**London Borough of Havering (20025659) – Written Summary of Issue Specific Hearing 3 Oral Submissions**

Thank you for the opportunity for LB Havering to attend and give evidence at the Examination Hearings for the M25/J28 Improvement Scheme Development Consent Order (DCO).

Figure 2.1: Site compound access

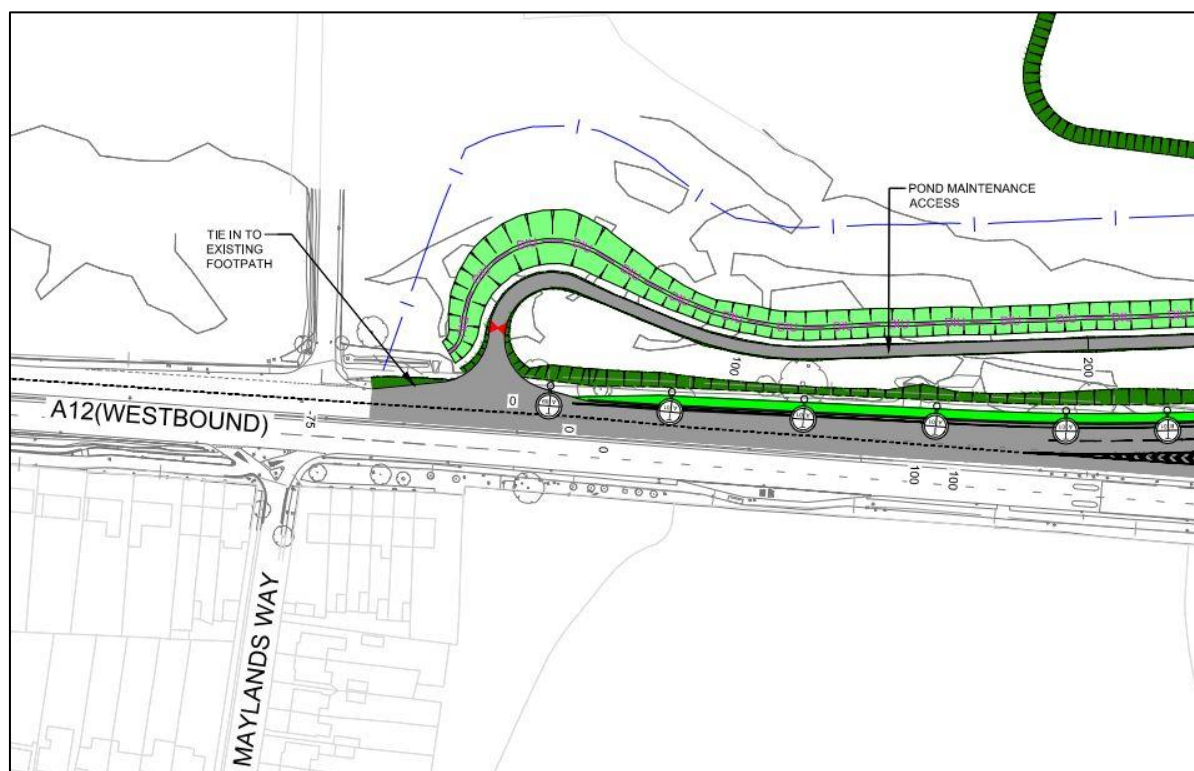
The TMP further acknowledges that construction traffic accessing the main compound will instead have to use the Gallows Corner roundabout. LB Havering would reiterate the concerns it expressed at Issue Specific Hearing One about the potential impact of construction traffic on the Gallows Corner junction. As no detailed analysis of the junction's performance in a 'with construction traffic' scenario is available, LB Havering would also suggest that HGV movements should be restricted to outside the morning and afternoon peak period when the impacts on the network will be greatest.

Appendix E: Petersfield Avenue vehicle swept path analysis

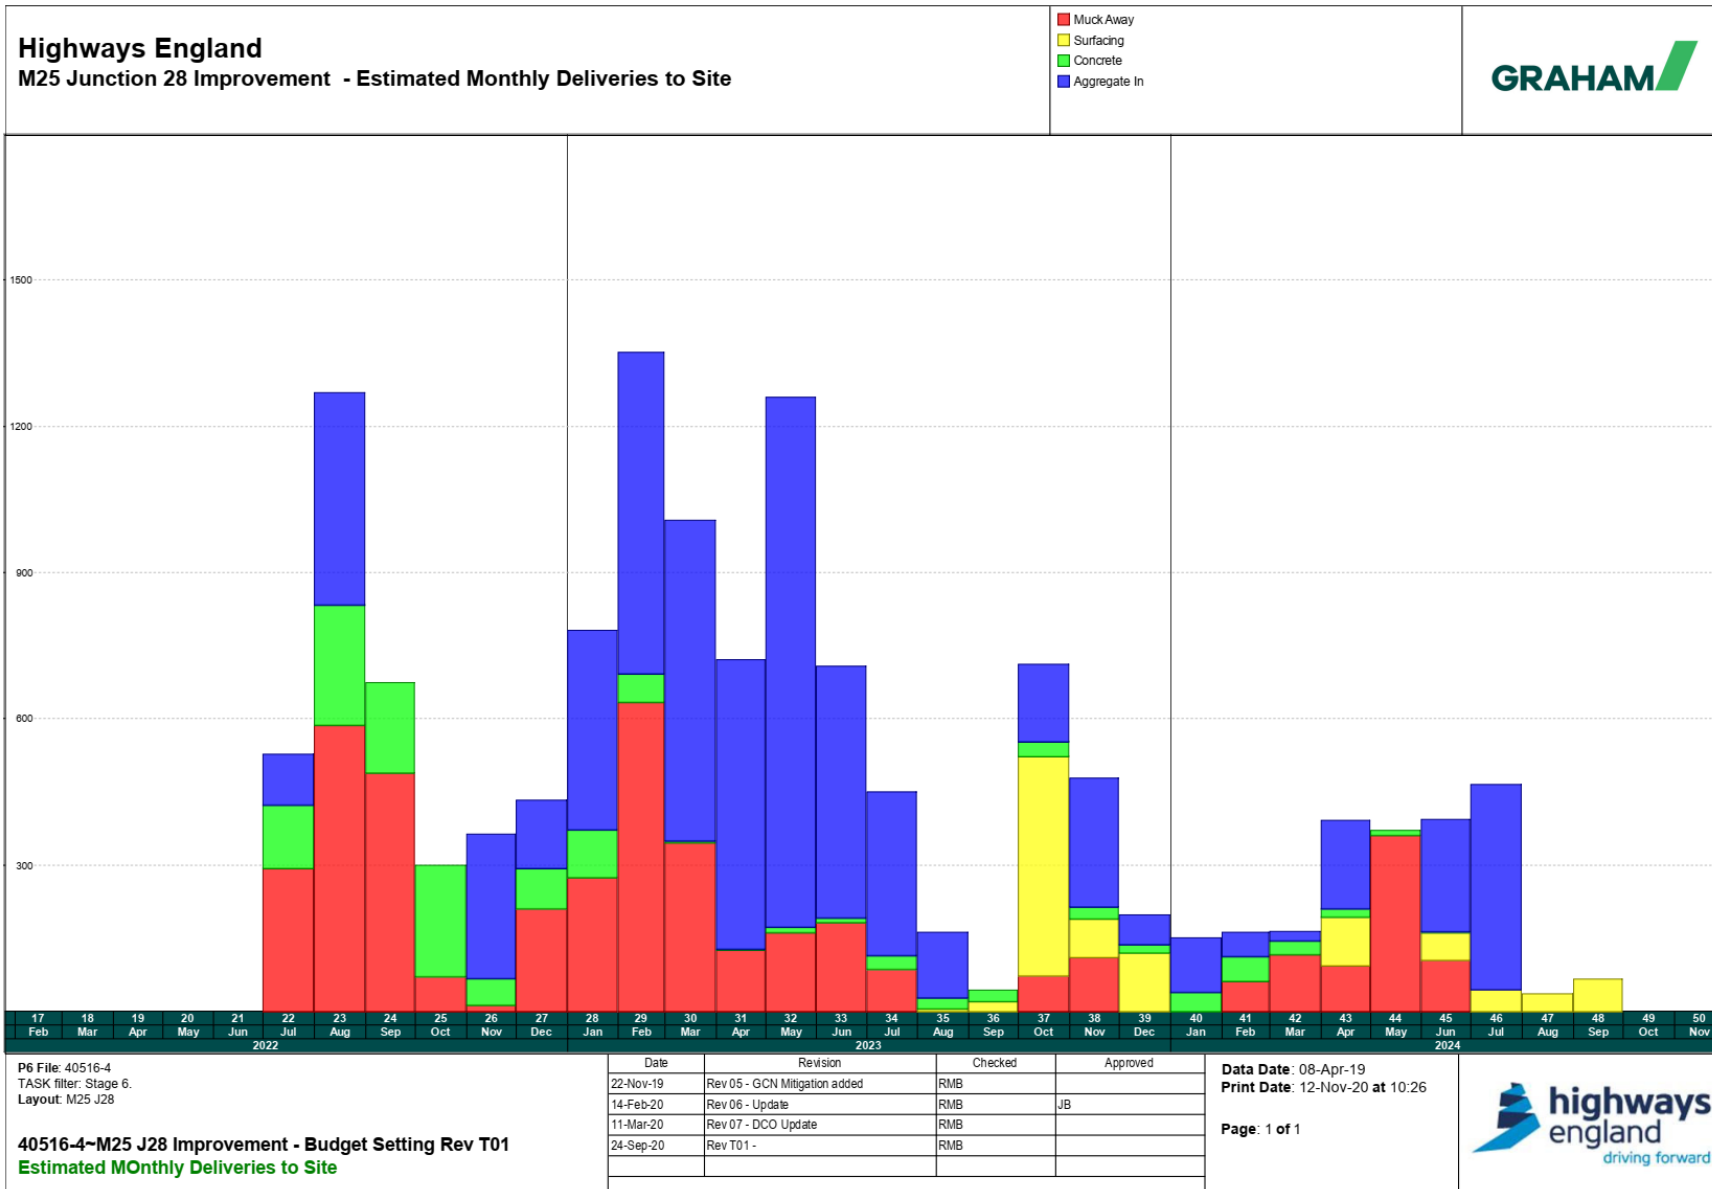
LB Havering notes that the Applicant has acknowledged in paragraph 2.3.5 that the existing junction at A12 / Petersfield Avenue is not wide enough to enable construction vehicles to make a U-turn.
